Planning application 22/00489/F: Erection of 49 no. dwellings, Shenington

We wish to state our **STRONG OBJECTION** to this planning application.

TITLE: STREET SCENE

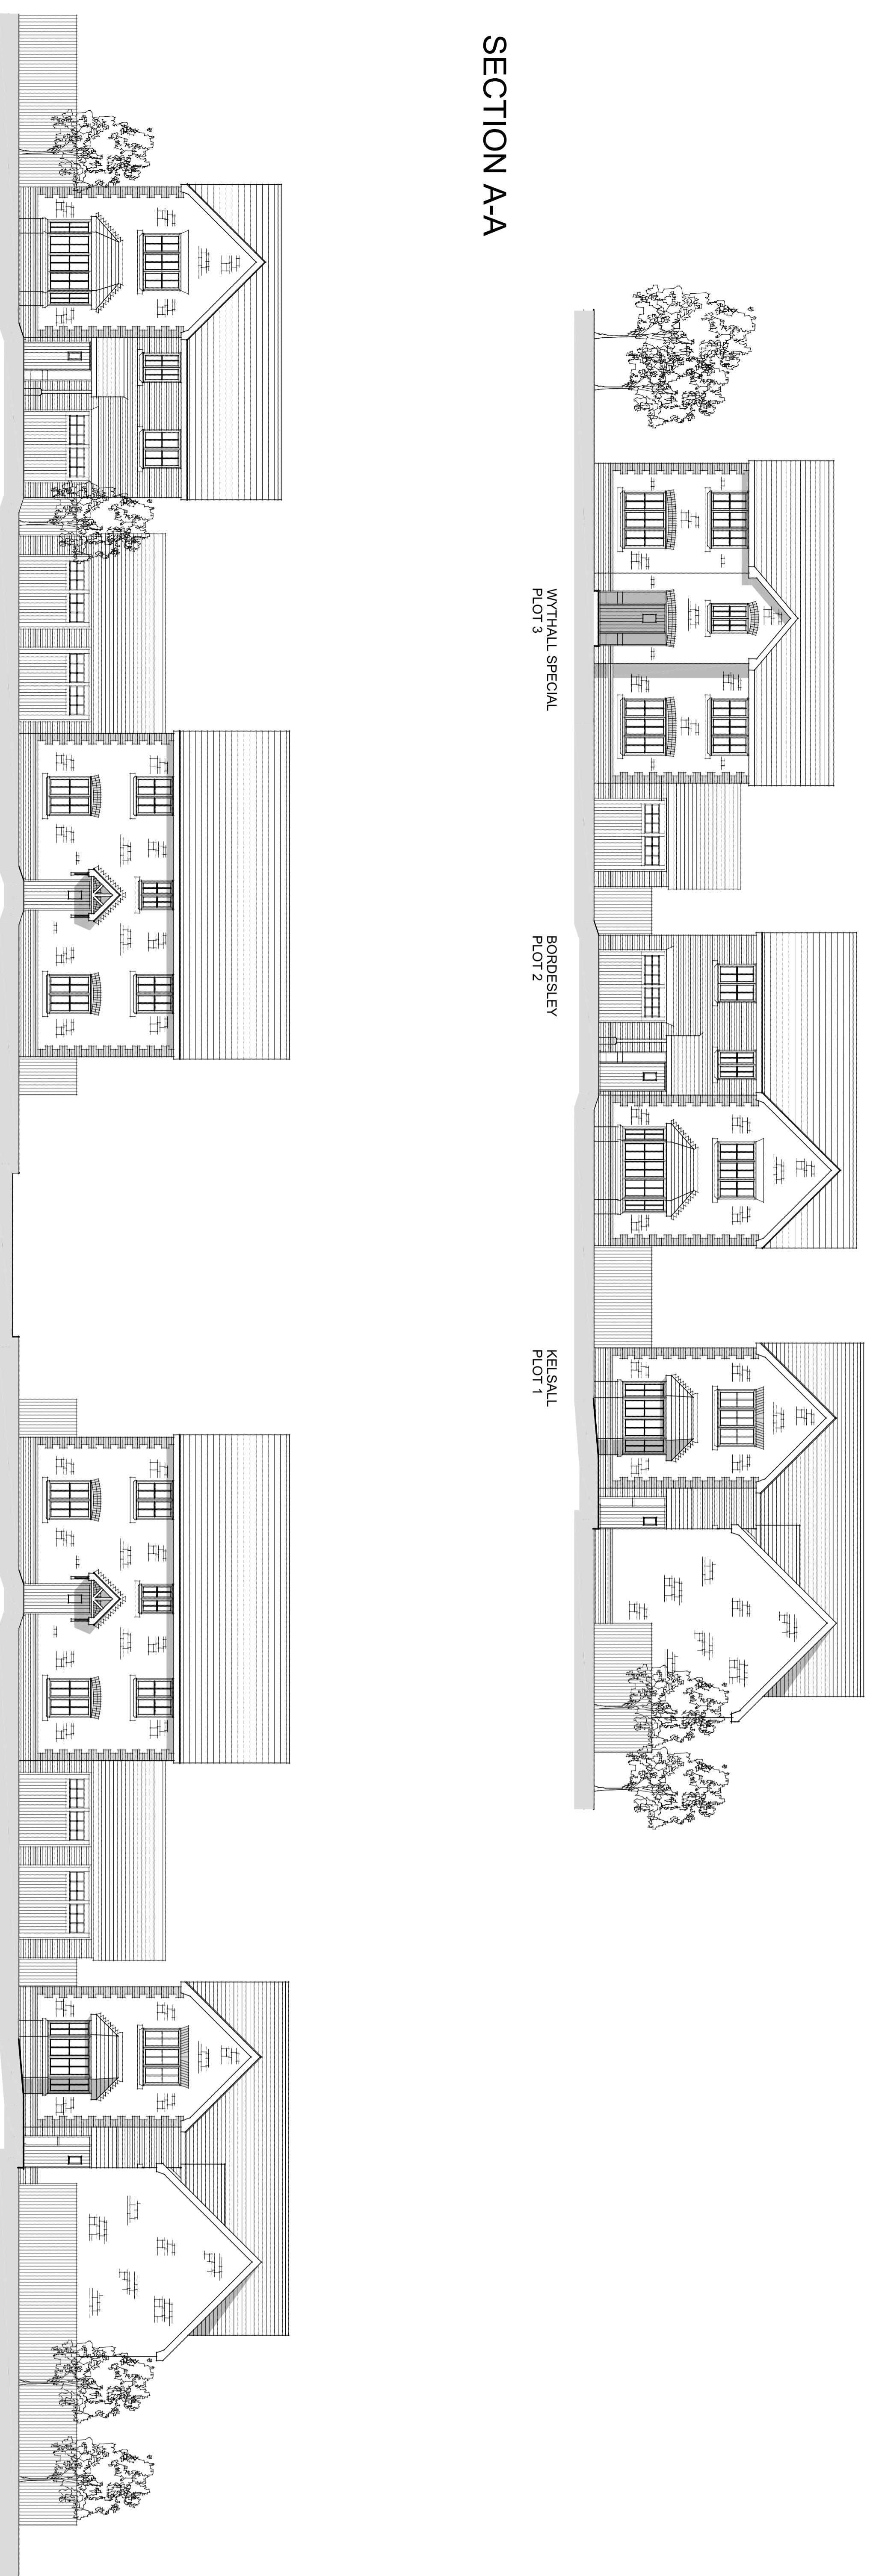
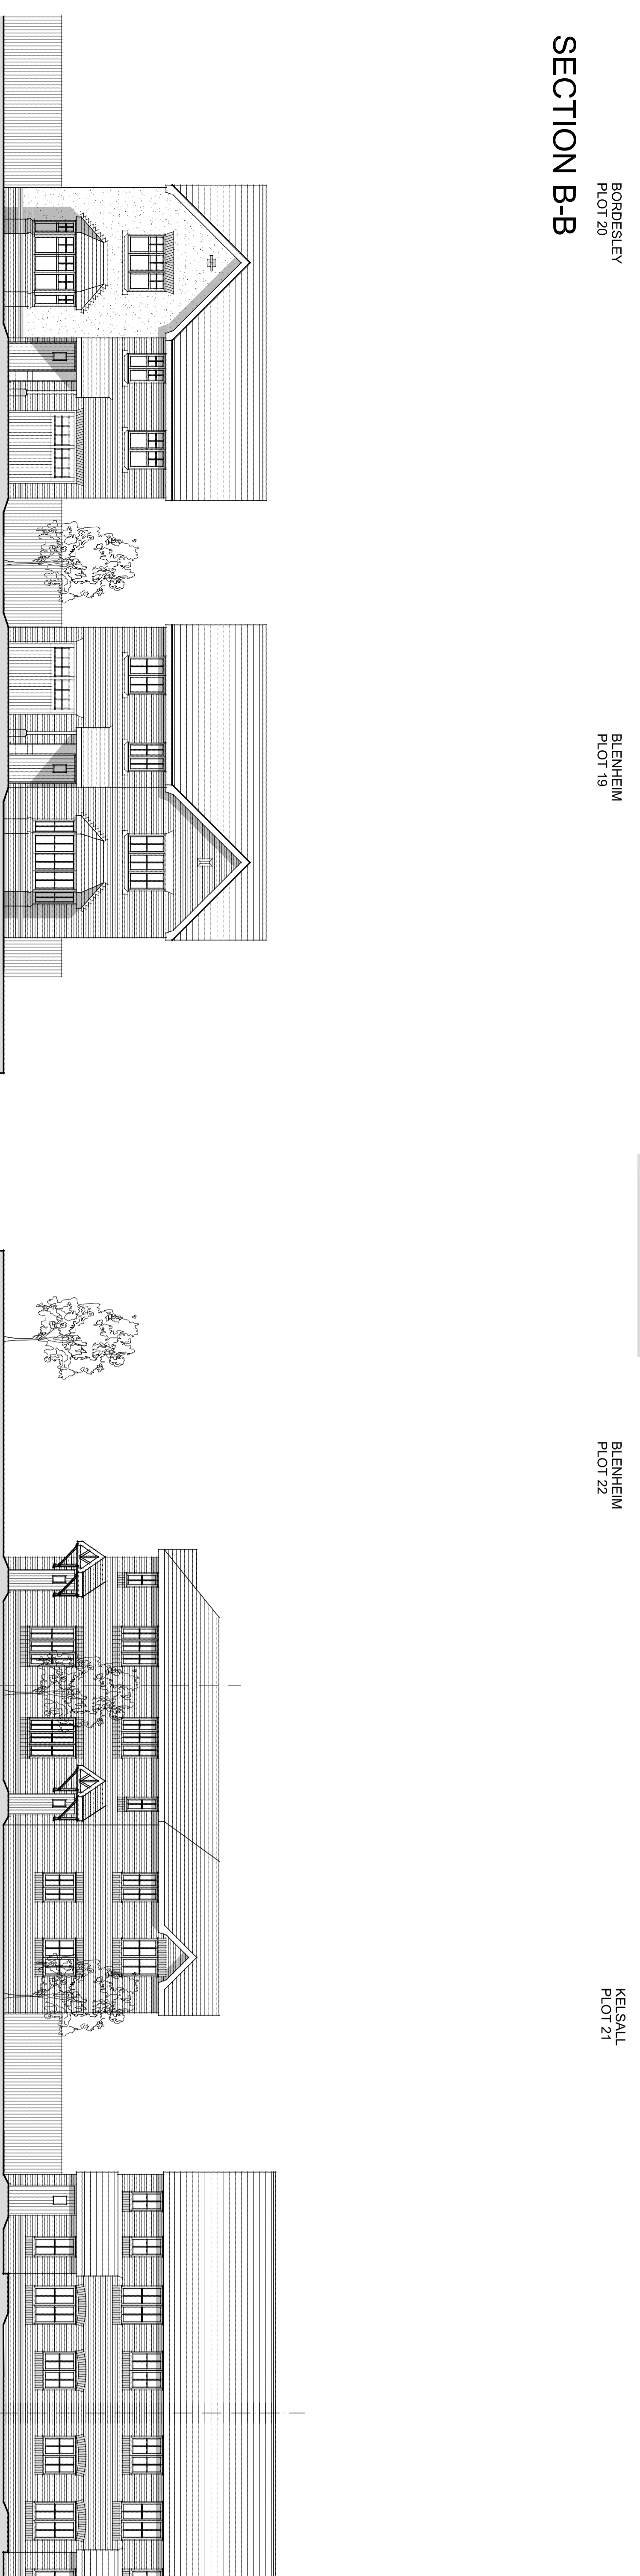
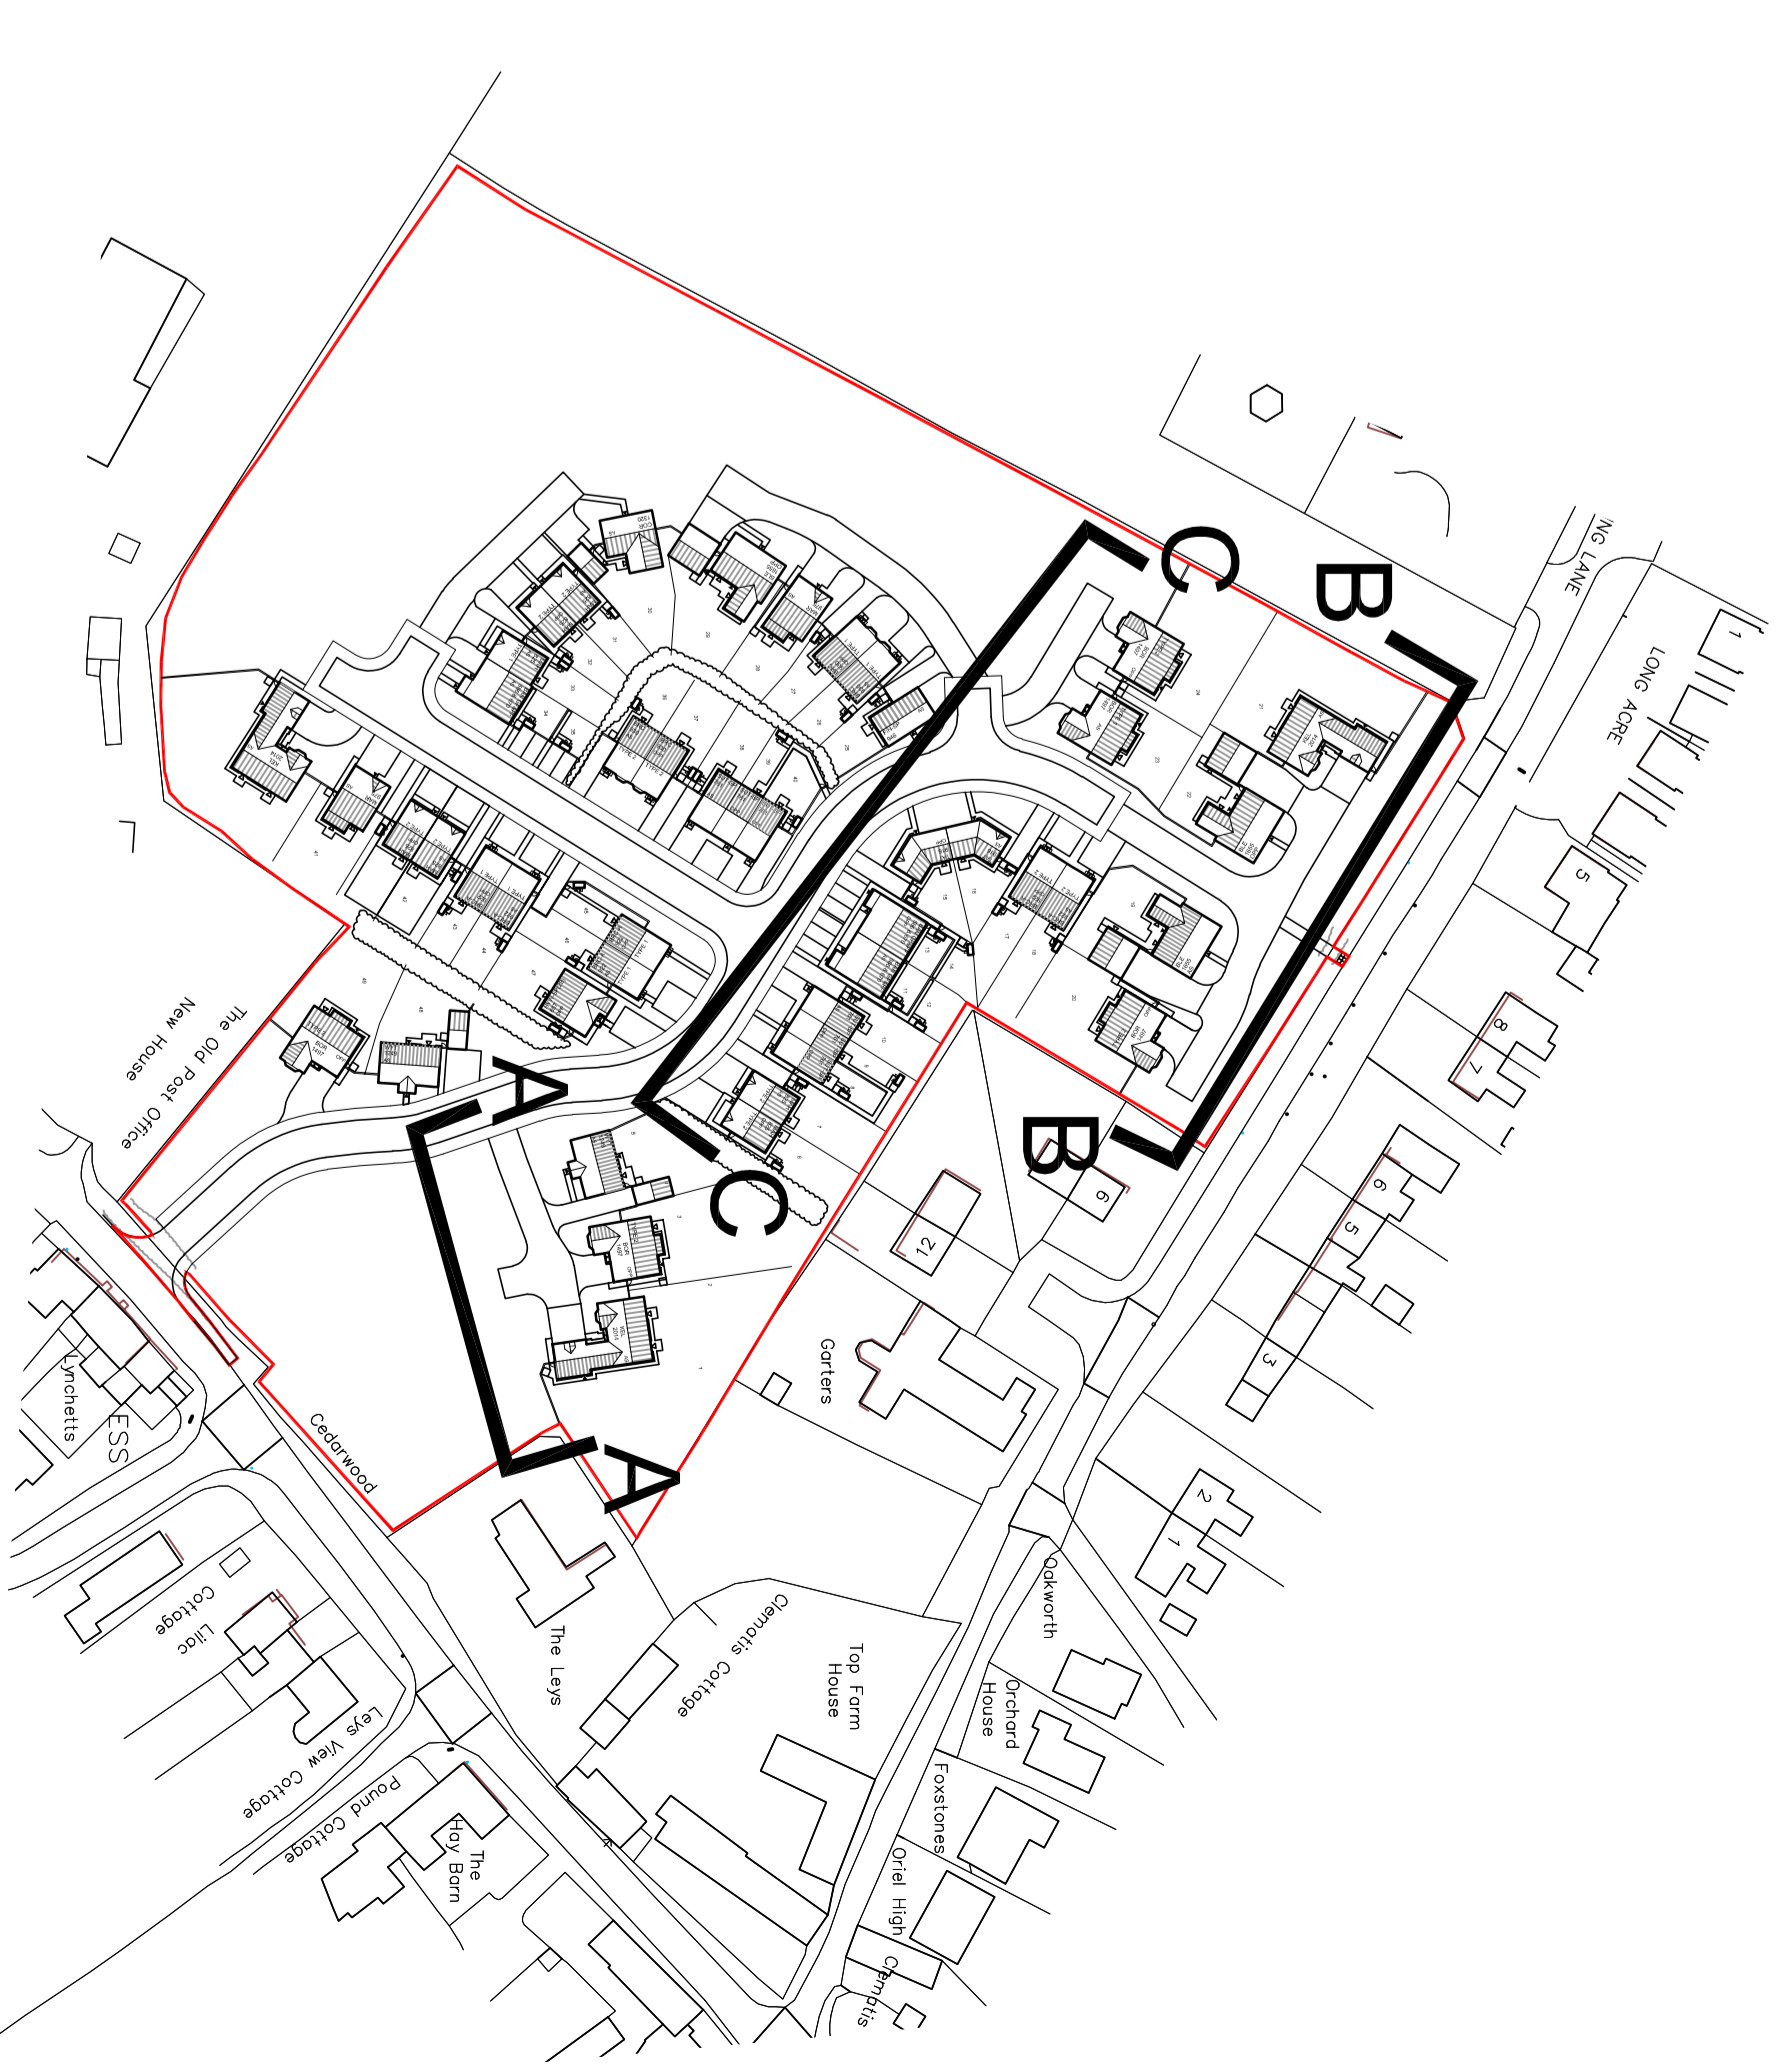
3. The proposed dwellings, by virtue of their number, layout, scale, siting, design and proposed materials are considered to represent an unsympathetic form of development that has a poor relationship with the existing built form of the village and through the introduction of this amount of development in this location would result in visual harm to the open, rural character of the area and village setting, and significant harm to the setting and significance of the Conservation Area, contrary to Policy ESD15 of the Cherwell Local Plan 2011-2031 Part 1, saved Policies C23, C27, C28 and C30 of the Cherwell Local Plan 1996 of the Cherwell Local Plan 1996 and Government guidance in the National Planning Policy Framework. It is also not clear whether the existing ironstone wall to Rattlecombe Road would be lost or compromised.

In contrast, the palette of materials proposed by the applicant is completely at odds with the village vernacular. The use of off-white render, buff brick, vertically-hung red tiles and re-constituted stone (read 'concrete') is plainly at odds with property within and without the Conservation Area and demonstrates that the applicant has had no regard to local character.
